REQUEST	Current zoning: B-2(CD), general business, conditional district, CC, commercial center Proposed zoning: B-2(CD) general business, conditional and B-2(CD) S.P.A., general business, conditional, site plan amendment, CC, commercial center, and CC S.P.A., commercial center, site plan amendment, Lower Lake Wylie Protected Area.
LOCATION	Approximately 70.91 acres located on the southwest quadrant of the Mount Holly Road / I-485 Interchange
SUMMARY OF PETITION	The petition proposes to amend the previously approved site plan to allow for a minor reduction in the number of townhome units and changes to the overall square footage permitted for the retail/restaurant, office and automotive sales uses. While a slight increase in the maximum square footage for retail and restaurant uses is sought, the proposed amount of square footage for office and automotive sales has decreased. No changes are proposed for the hotel use.

STAFF RECOMMENDATION	The petition is consistent with the land use recommendations set forth in the <i>Mount Holly Road Special Project Plan (1994)</i> , which was amended by a rezoning in 2005 from single family residential, multi-family residential and industrial use

SHEET NO.  
**TDS-2**

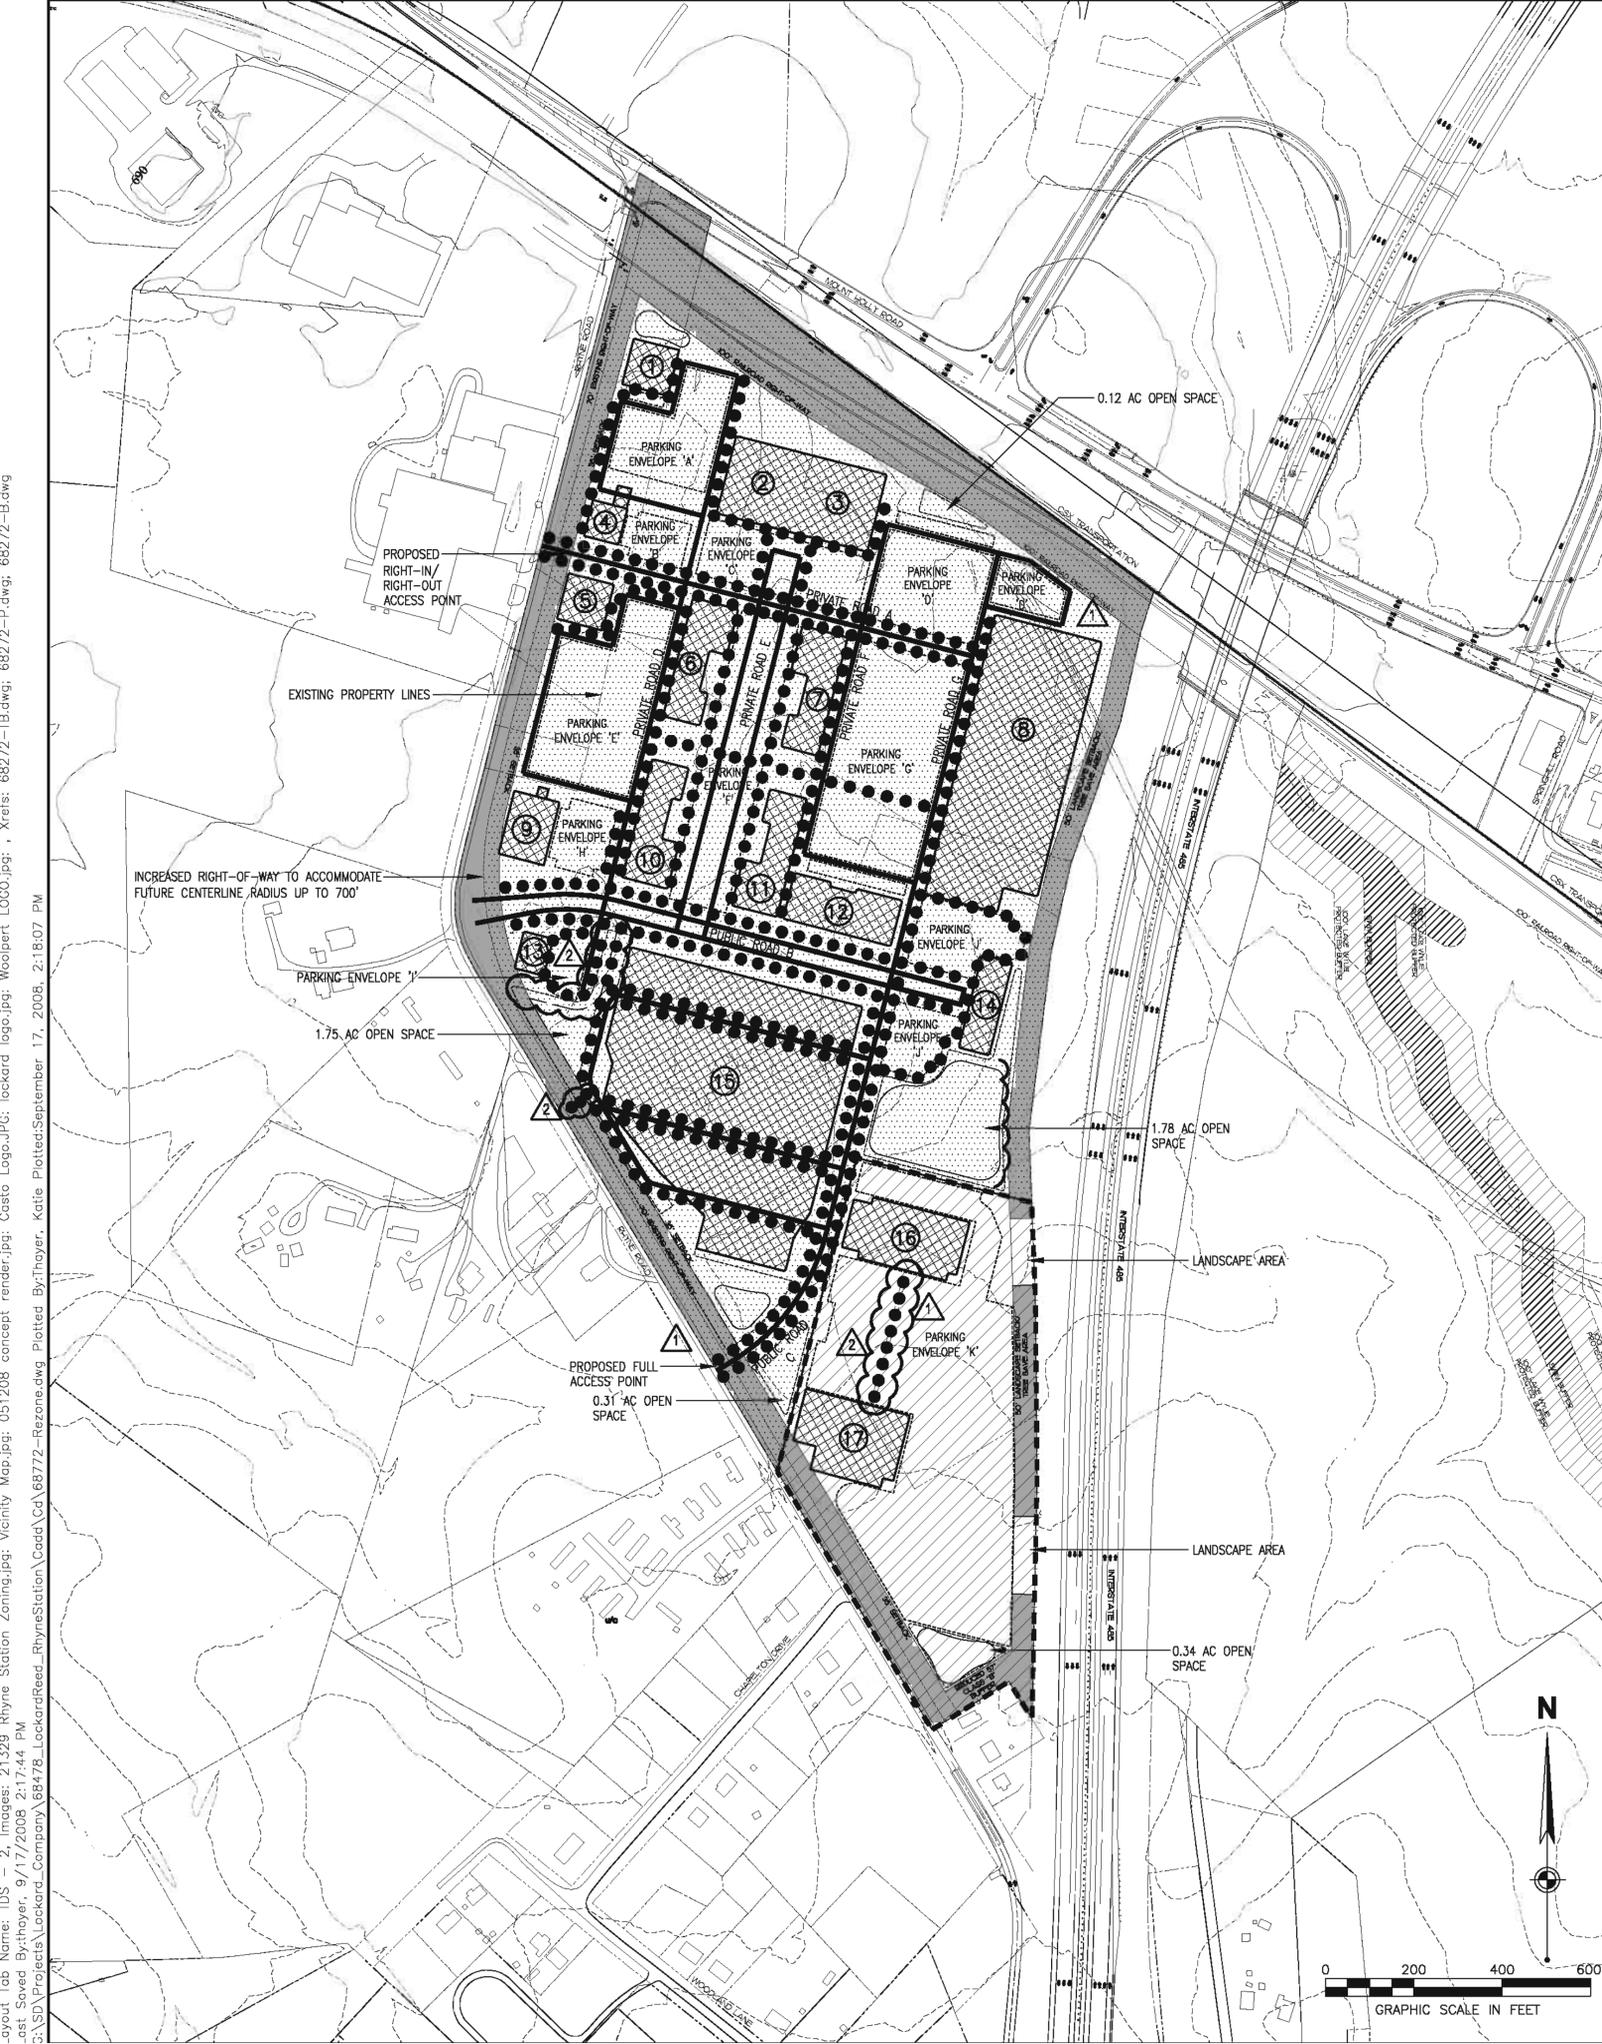
1. The petitioner should provide a landscaped setback along Rhyne Road.
 2. The petitioner should clarify the square footages for retail and restaurant as they do not match the maximum square footage listed on sheet TDS-2.

3. The petitioner should add connected sidewalks through the parking lot between car dealerships.
 4. The petitioner should amend Note 4 under Sidewalks and Internal Streets to specify street trees will be 40 feet on center.

5. The petitioner should amend Note 5 under Buffers to state that a Class B buffer will be maintained along the southern property line for the B-2(CD) zoning.

6. The petitioner should provide a landscape treatment, such as a wall/fence, trees, and shrubs, along Public Road B if townhomes do not front Public Road B.

7. The petitioner should provide internal sidewalk connections from townhomes to Public Road B.
 8. The site plan should indicate a 25-foot Class B buffer between the townhomes and the commercial outparcel.

9. The petitioner should show the proposed streetscape treatment in the multi-family component.
 10. The petitioner should add note that allows a sign flex option.
